Sheringham Shoal and Dudgeon Offshore Wind Farm Extension Projects

The Applicant's Comments on the Maritime and
Coastguard Agency's Deadline 6 Submission

Document Reference: 21.11

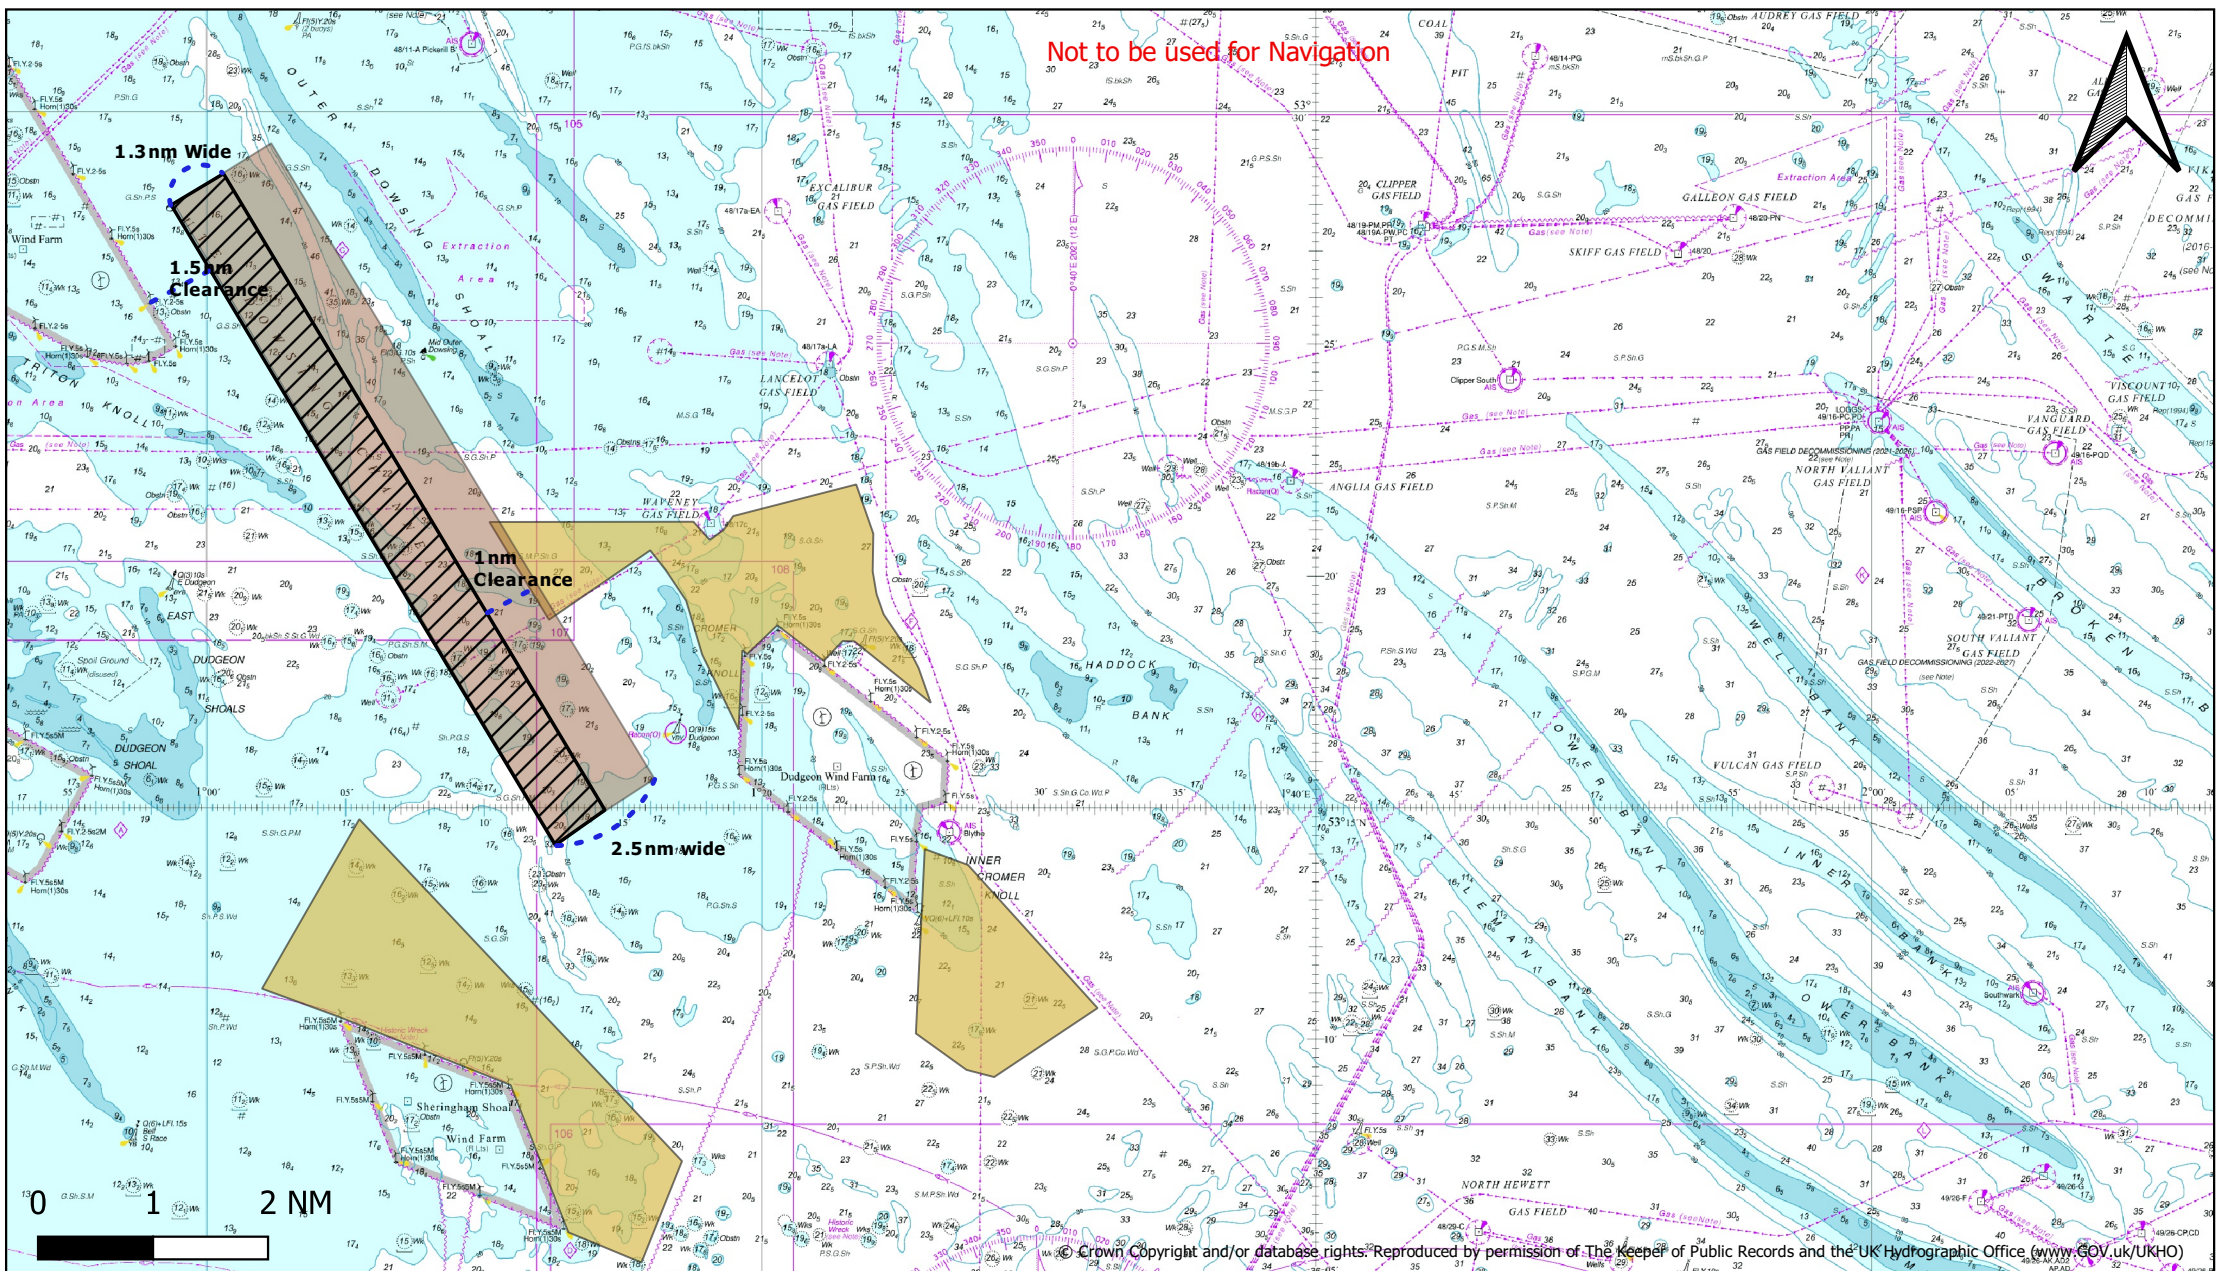
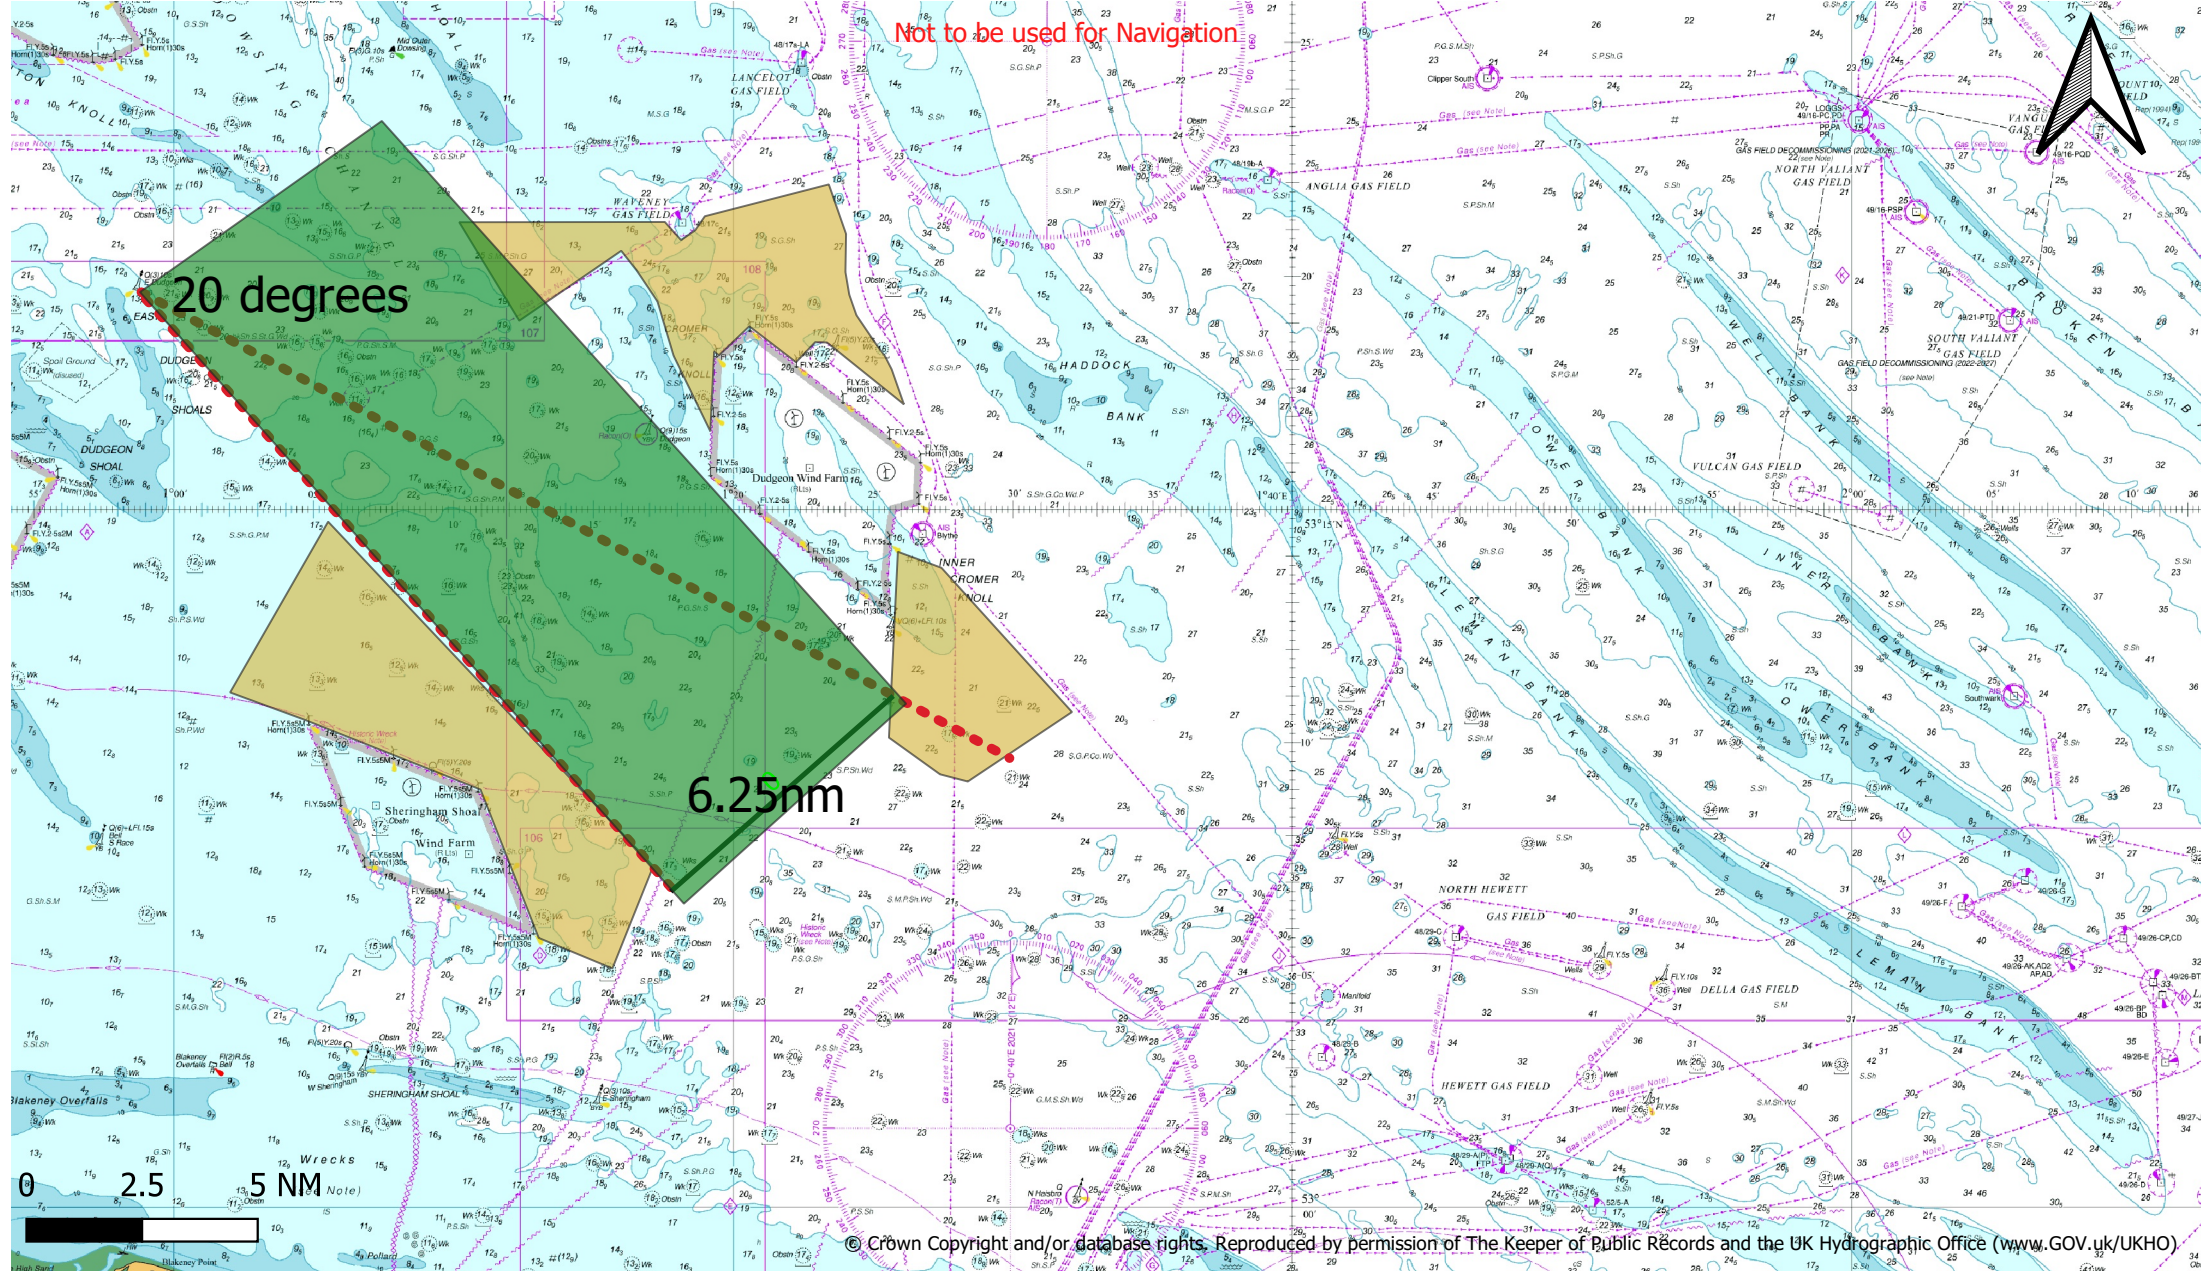
"it is likely that 90% of vessels will be constricted into a navigable space of 1NM wide. This does not appear to have been considered for assessing the potential frequency of encounter and collision likelihood scores within the hazard log" and that based on this *"The predicted increase of 13% collision frequency at current traffic levels may have been underestimated, in which case changes to the red line boundaries must be considered"* (emphasis added).
16. At ISH6 the MCA would quantify this as a constriction of the 90th percentile traffic width to 1.3nm (Page 1 of ISH6 Maritime and Coastguard Agency's Deadline 1 Representation [AS-044]) when giving a buffer of 1nm to the DEP-N array area.
17. This was reiterated at Deadline 5 where in answer to Q3.19.1.2 the MCA stated:

"When a safety buffer of 1NM is applied to the DEP North boundary, our assessment is that vessels will be constricted into a channel 1.3NM wide." [REP5-081].
18. In discussion with the MCA the Applicant has clearly demonstrated that the collision risk modelling within the NRA has considered a constriction of traffic to a width of 1nm and therefore the predicted increase in collision frequency was not an underestimation. Charts to this effect were included in the Applicant's Deadline 5 submission [REP5-050].
19. At ISH7 the MCA, Trinity House and Chamber of Shipping all agreed, when viewing Figure 1 below, that the assumptions upon which modelling were based represented a worst-case scenario with the MCA stating:

23. The MCA position suggests the 90th percentile of traffic would sit at 1nm from any structures. Whilst there is safe navigable area to the west for this to occur, applying this assumption when also maintaining a worst-case constriction to 1nm traffic width, would only reduce allision risk (as vessels would be passing further from the structures) and therefore not represent a worst case for both collision and allision.

24. The MCA's own guidance (MGN 654) (**Appendix C**) states that a 0.5nm to <1nm distance of shipping route (90th percentile of traffic) to boundary can be 'tolerable if ALARP' and that 1nm is the minimum distance to parallel an IMO routeing measure of which there are none in the study area.

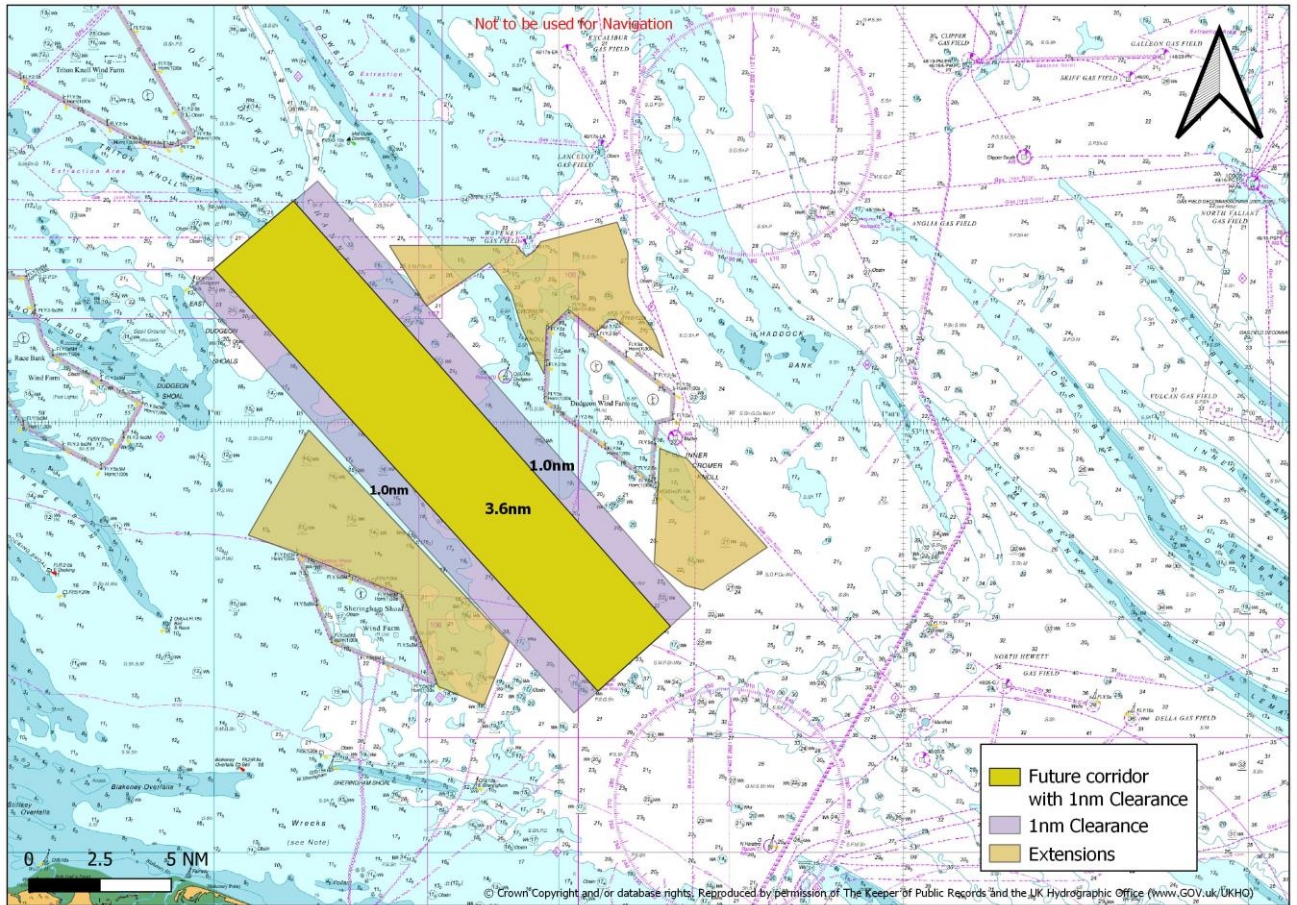
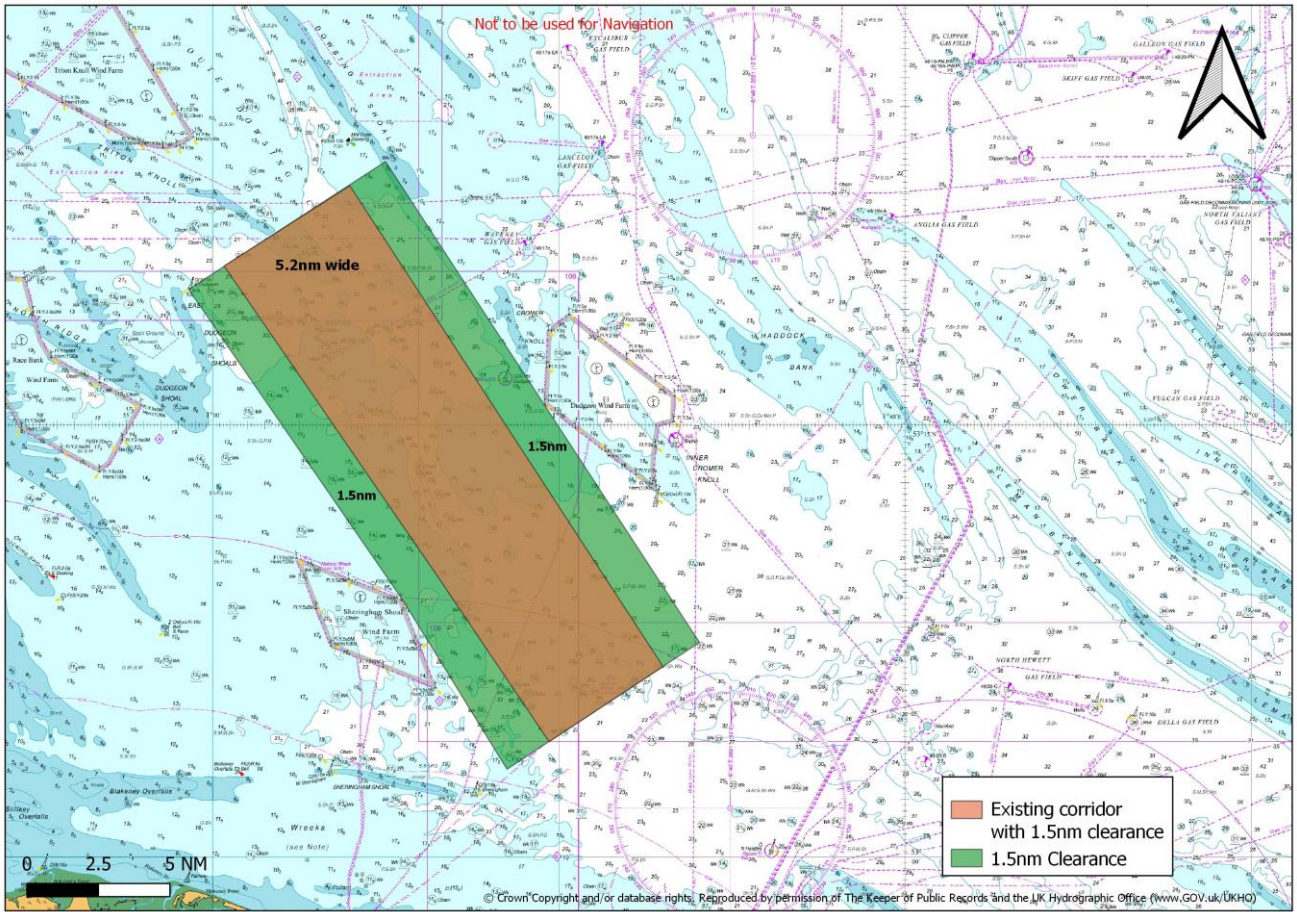
28. At Deadline 3 when asked to provide the background evidence to support their position relating to the matters discussed at ISH6, the MCA provided a calculation for adequate sea room to allow four vessels to safely pass each other in the Outer Dowsing Channel [REP3-134]. Using a vessel length of 195m this gave a suitable width of 3.24nm.
29. Beyond the calculation described in this section the MCA have not provided any background evidence to calculate what sea room they consider adequate. This

30. When applying this width from what the MCA had identified as the controlling depth of 15.3m of the wreck in the west of the channel this correlates with the line formed by the Mid-Outer Dowsing buoy and Dudgeon buoy. Figure 3 below illustrates the MCA's original calculation.

31. However, in doing so, the MCA sought to apply a combination of PIANC guidance¹ and Nautical Institute and The World Ocean Council guidance². These are primarily intended to be used where there are two wind farms either side of the shipping route, which is not the case here. As a proxy for the other (non-existent) wind farm, the MCA has treated a wreck at 15.3m depth as fixing the boundary of the (non-existent) other wind farm.

35. The MCA is using the 15.3m wreck as the controlling depth in the Outer Dowsing Channel. The Applicant considers the 10m contour as the controlling depth and this is supported by Trinity House (Figure 4 of Deadline 5 Submission [REP5-096]) and reiterated at ISH7 where Captain Harris stated: "*we are marking the 10m contour which we consider to be the controlling depth.*" (49:32 [EV-095]). The controlling depth in a sea route is fundamental to its marking for safe passage. This is a core area of expertise of Trinity House, whose expert regulatory remit specifically covers marking channels and hazards.

36. In light of this helpful clarification by Trinity House, the Applicant has considered what the MCA's position might be assuming that it may conclude that the same calculation should be applied but be taken from the correct starting point for the controlling depth i.e. the 10m contour. Using the same MCA calculated width of 3.24nm but starting from the 10m contour the overlap with DEP-N boundary is as shown Figure 4 below.

37. The mistake regarding the controlling depth is a fundamental error of fact by the MCA which undermines its case for a no structures area set by the line between the Mid-Outer Dowsing buoy and Dudgeon buoy. When the correct controlling depth (i.e. 10m) is applied a much smaller no structures area results.
